April 12, 2021

Re: Hansen Road Development

Miscellaneous SEPA Applications - SE-21-00006 Nunnally Holdings

DRAWING NO.	C1.1
PROJECT NO.	20.010
DATE:	11/23/20
SHEET NO.	2 OF 10

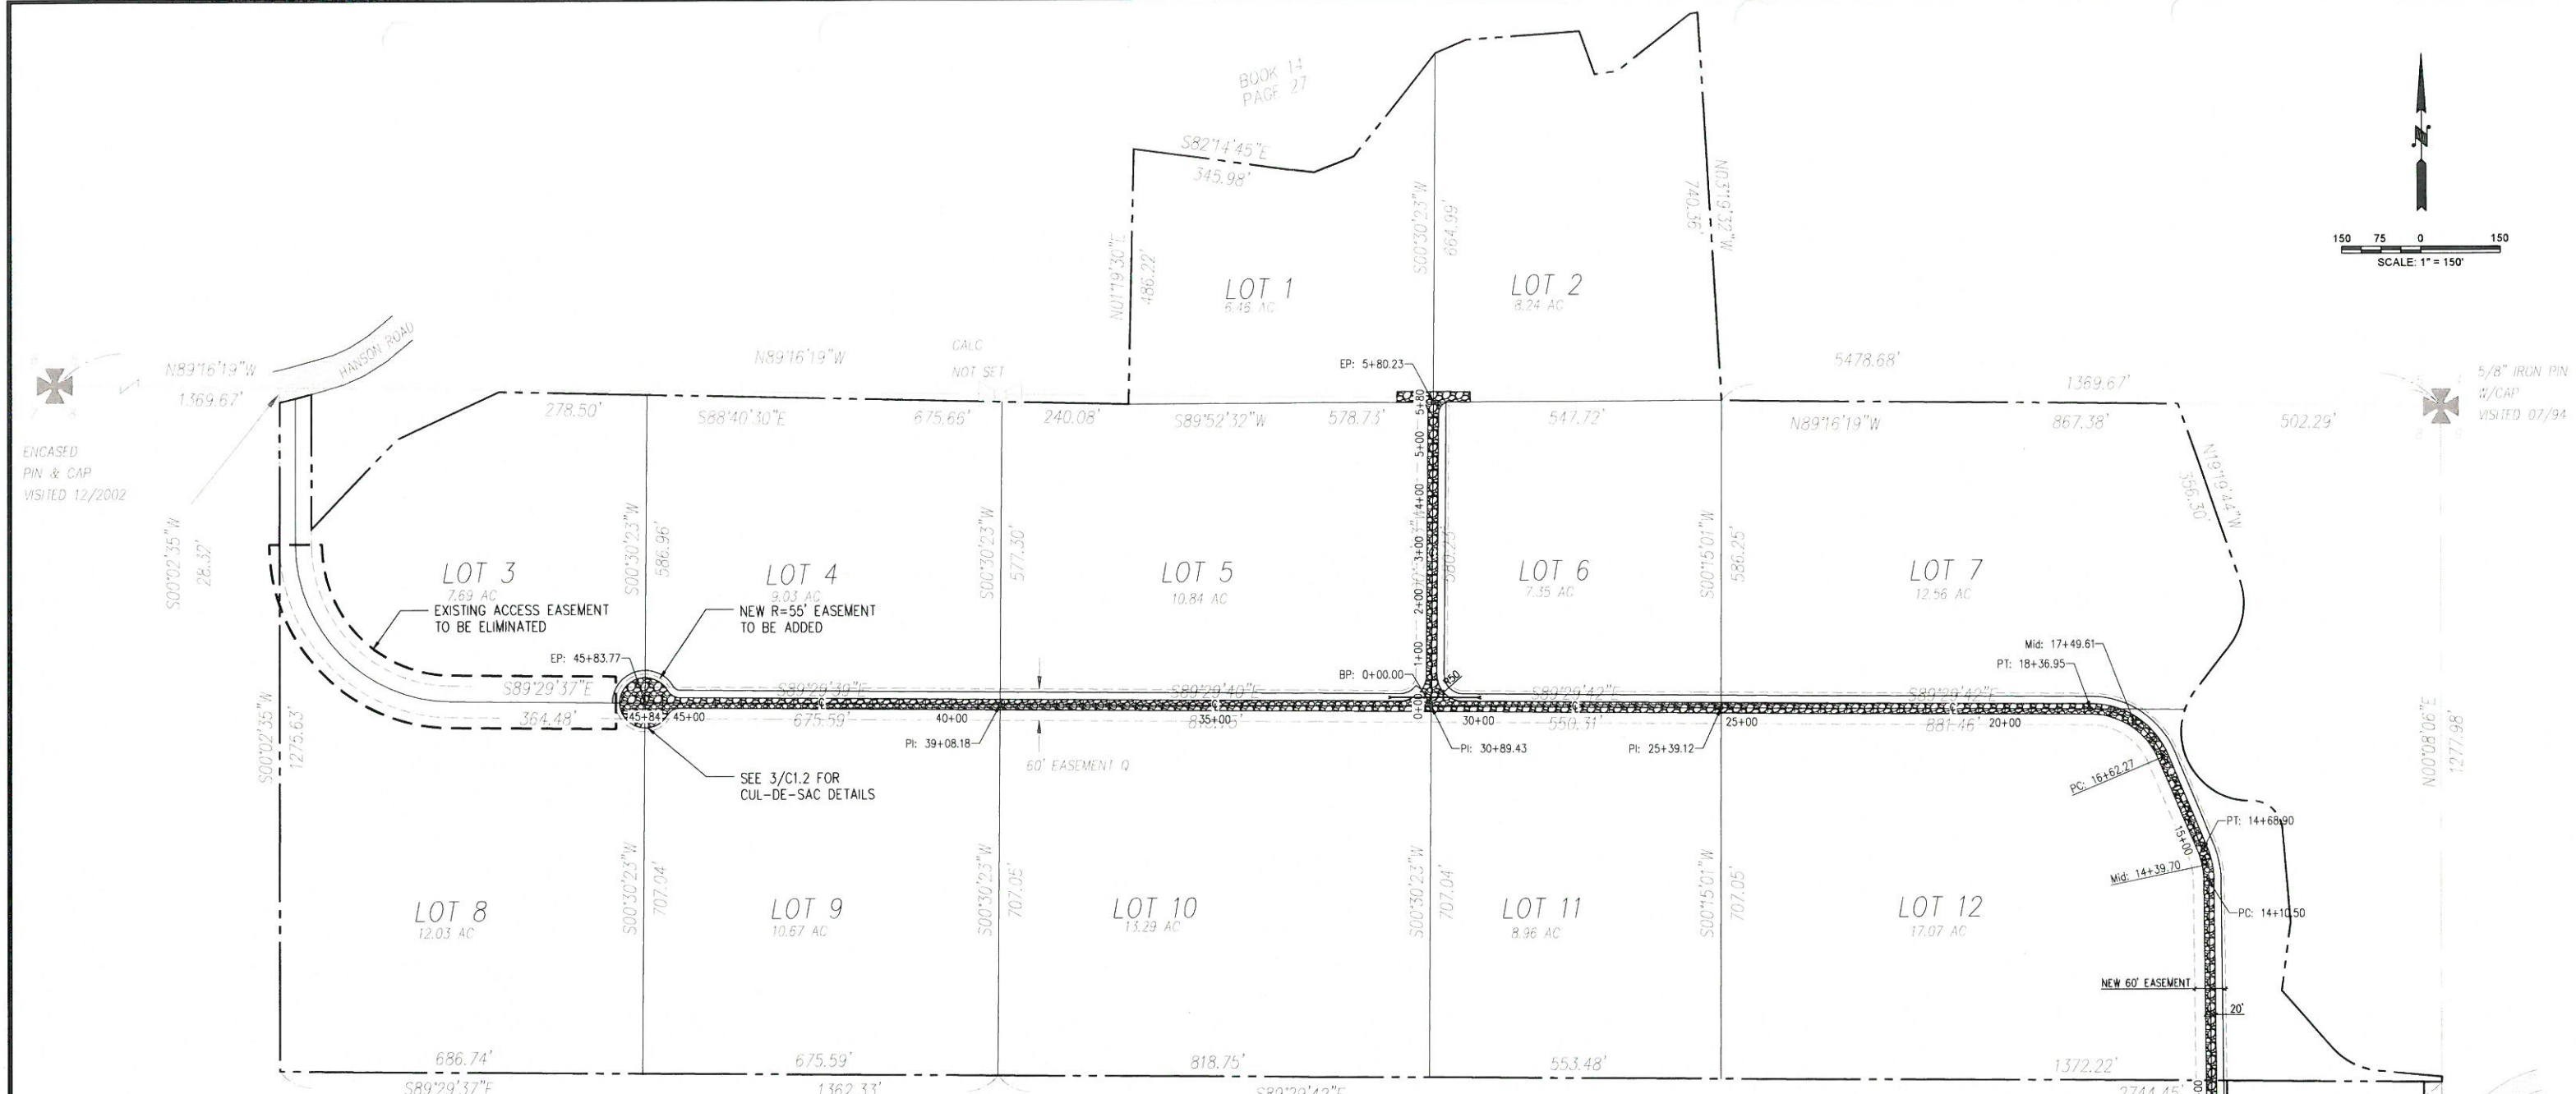
Parcel 13 is incorrectly labelled on the project maps provided within the construction documents for the project site.

DRAWING NO.	C1.4
PROJECT NO.	20.010
DATE:	11/23/20
SHEET NO.	5 OF 10

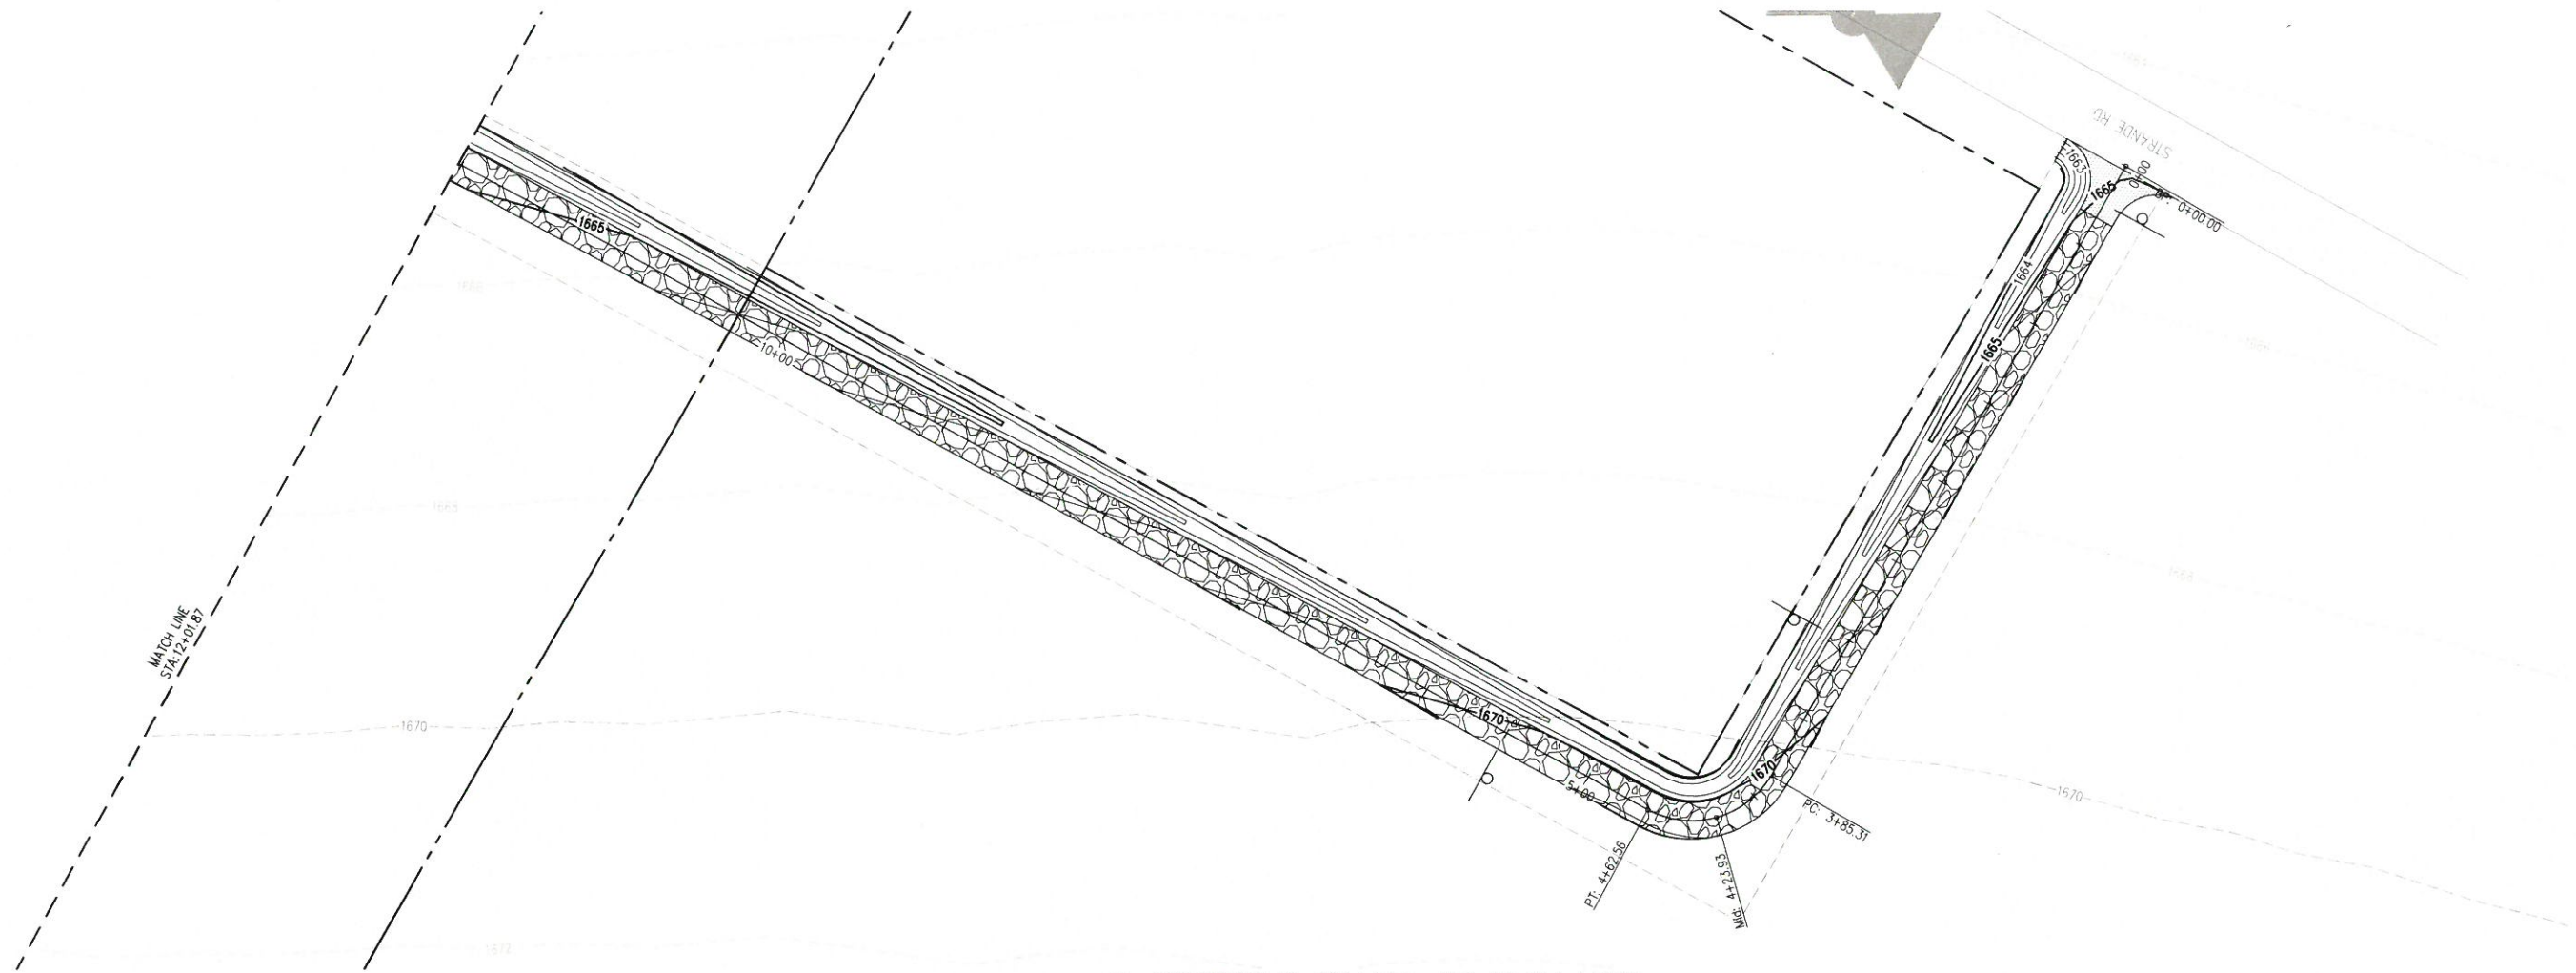
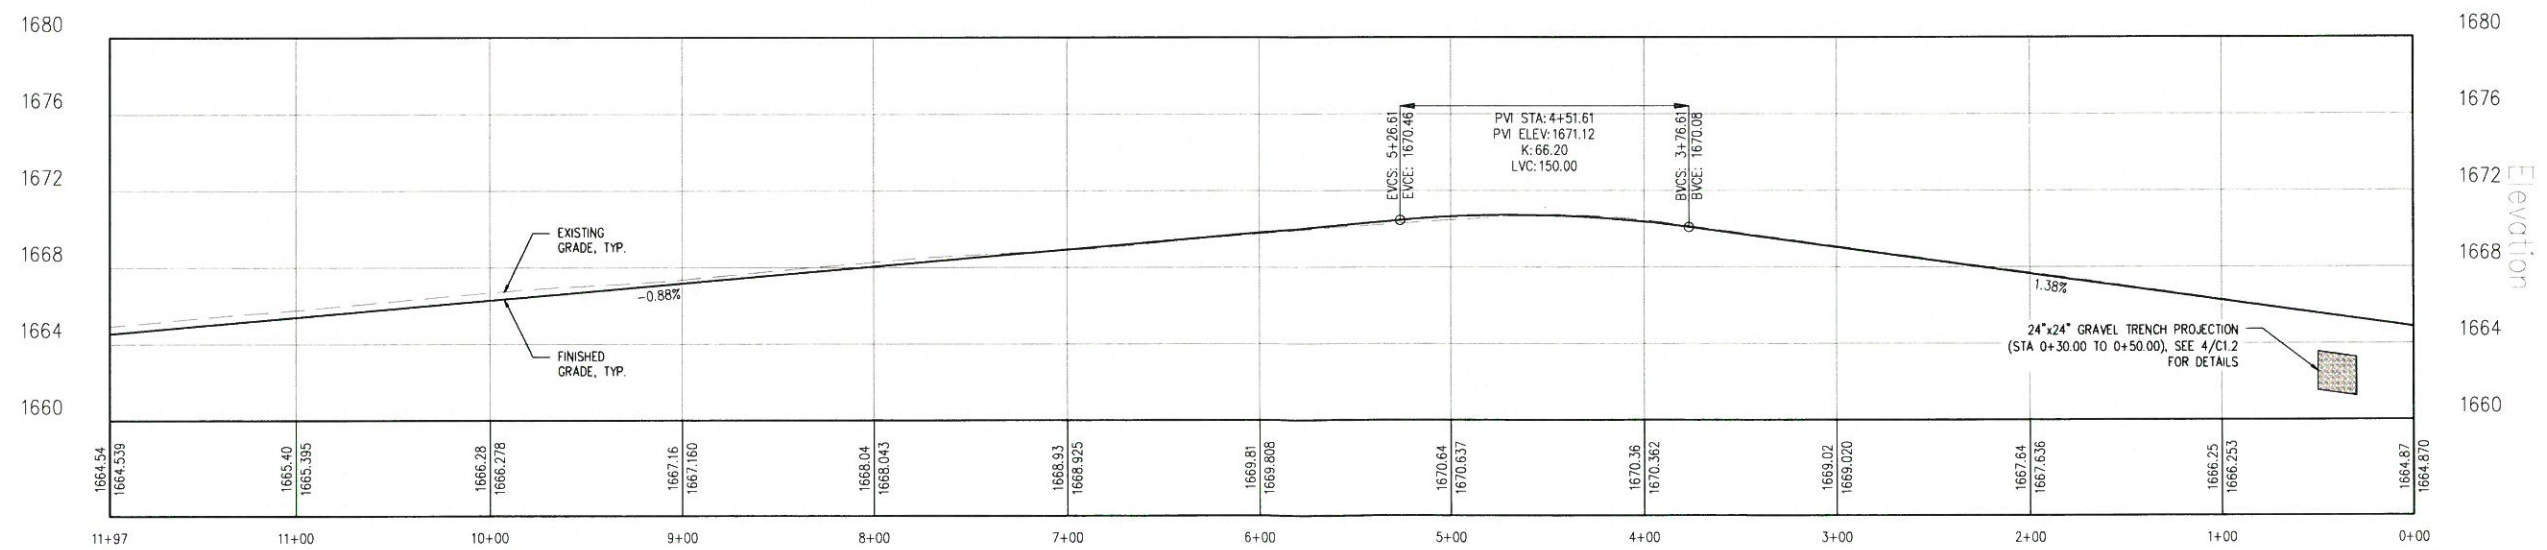
The developers grading plan includes a 4-foot profile grade between Strande Road Sta. 0+00 to the first curve at Sta. 4+24. The existing ground is flat, this grade change does

not exist. As a result the developer and his engineer must gather accurate topography and validate the existing conditions to design a roadway. Designing without accurate topography would result in an unnecessarily elevated roadway, additional embankment fill and a roadway design that will place stormwater from the developer's road at Sta. 4+24 the onto Parcel 836636. The grading plan does not include adequate information to address stormwater created by the new PGIS. Temporary and permanent drainage plans are required and must be designed to convey and contain stormwater on the project site. Culverts are required at driveway and/or access approaches.

The elevation of the proposed access road as currently designed in the grading plan would require additional fill be imported to the project site. The terrain is level and there is no elevation change between Sta. 0+00 to 4+23. It is impossible for existing terrain change proposed the developer and the engineer. The developer needs to collect a topographic survey to validate the terrain on the 34-acre parcel. The roughly 6 feet of elevation change directly affects the adjacent parcel and will result in stormwater runoff onto the adjacent parcel.
